Pagham Harbour proposed managed breach

Application: P/97/15/PL

Response to the application by RSPB

4 January 2016

**Block Plan Showing the
Proposed Compensation Area
(‘New Tern Island’)**

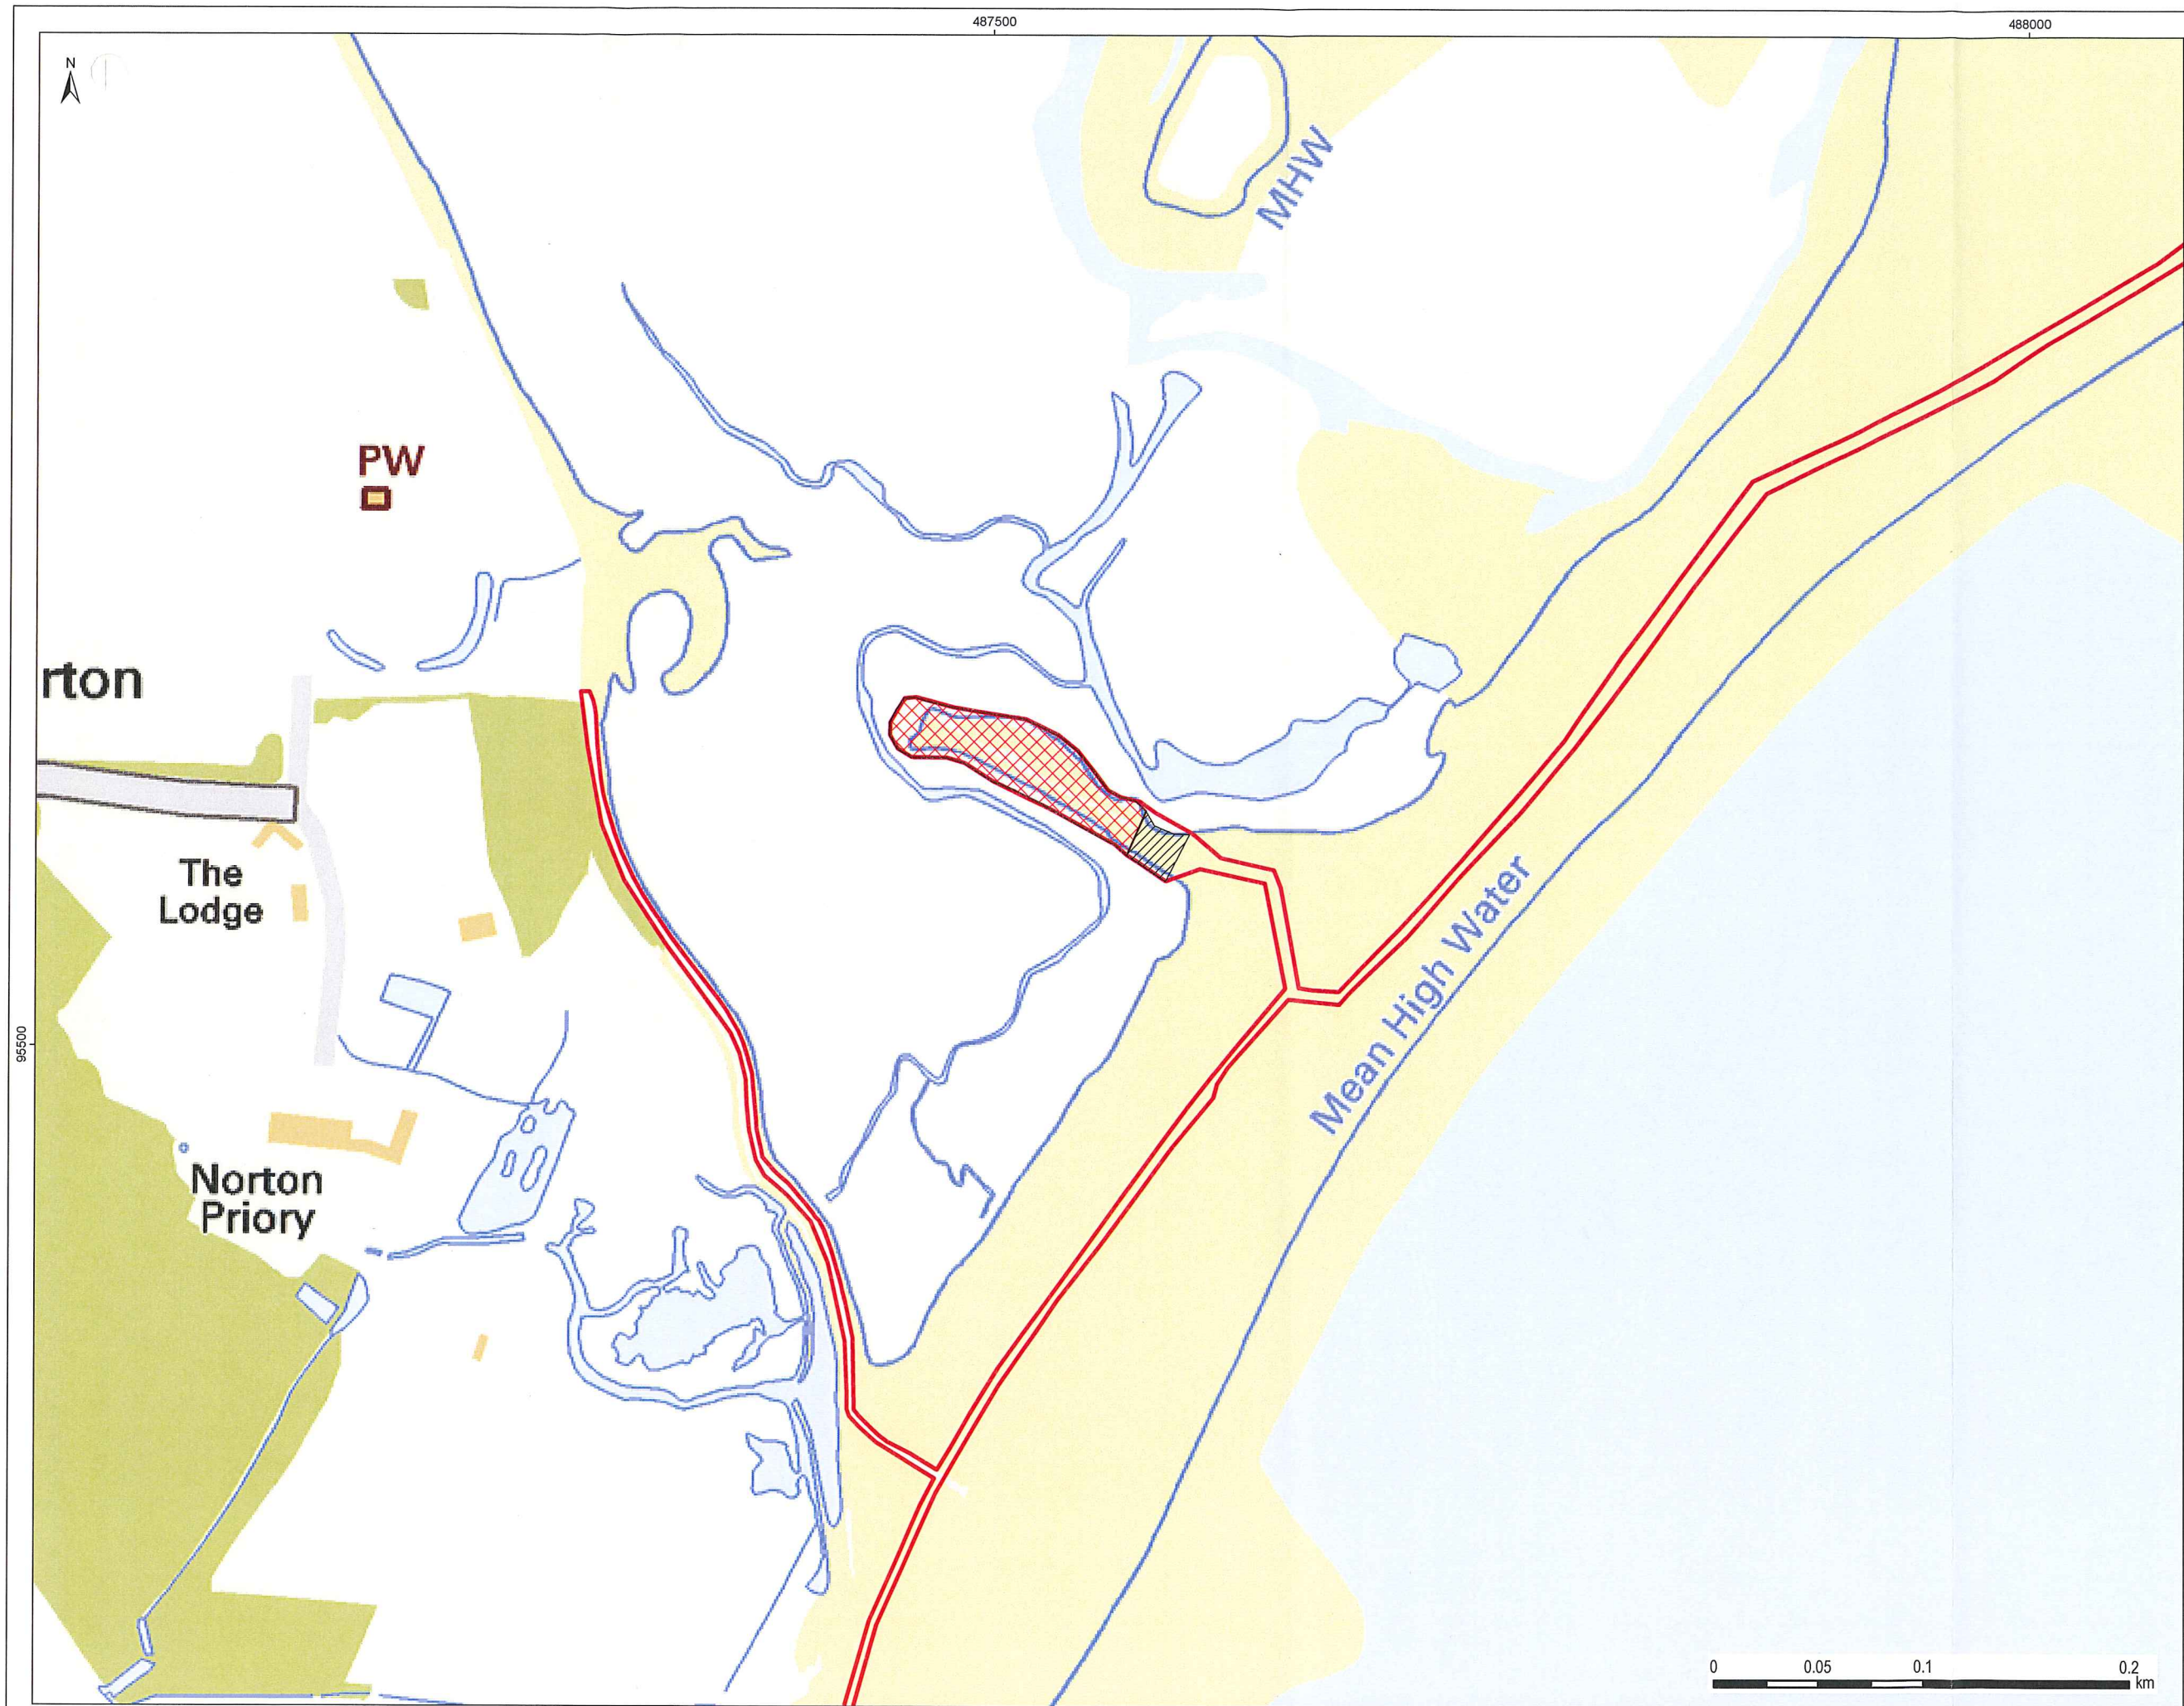
42. The application incorporates the creation of a new shingle island within the harbour, formed by the deposit of material upon an existing concrete revetment, to create a new breeding habitat for little terns. The ES incorrectly describes this as mitigation (e.g. page 16 of the Non-Technical Summary), but later correctly describes it as compensation (ES section 11.2.2, page 249). It should correctly be considered as a compensatory measure. As determined by the European Court of Justice judgement in the *Briels* case (Case C-521/12 *Briels v Minister van Infrastructuur en Milieu* 2014), where the predicted adverse effect cannot be avoided, the provision of alternative habitat for the impacted feature elsewhere within the boundary of the SPA should be regarded as compensation. It is predicted that the habitat supporting breeding little terns will be lost as a consequence of the proposed development and therefore it must comprise an adverse effect on the SPA that cannot be avoided.

43. The RSPB considers that, if appropriately designed and subject to ongoing management, notably vegetation control and anti-predator fencing, the support of appropriate wardening, and clarification of who is legally responsible for the compensatory measures, the proposed creation of a new shingle island within the harbour would be likely to provide suitable habitat to replace that which would be lost as the existing spit gradually erodes. The precise design of the island and the means of implementing its creation would need to be agreed with Natural England and the RSPB, and any consent should be conditioned accordingly.

44. In line with UK and EC guidance on compensatory measures, the new habitat should be provided in advance of the predicted adverse effect. The RSPB would welcome working with the Applicant and their consultants, the Councils and Natural England on an appropriate planning condition and associated agreement setting out the aims and objectives of the compensatory measures, along with the proposed construction methods and timetable in relation to the predicted impacts, appropriate management and monitoring measures.
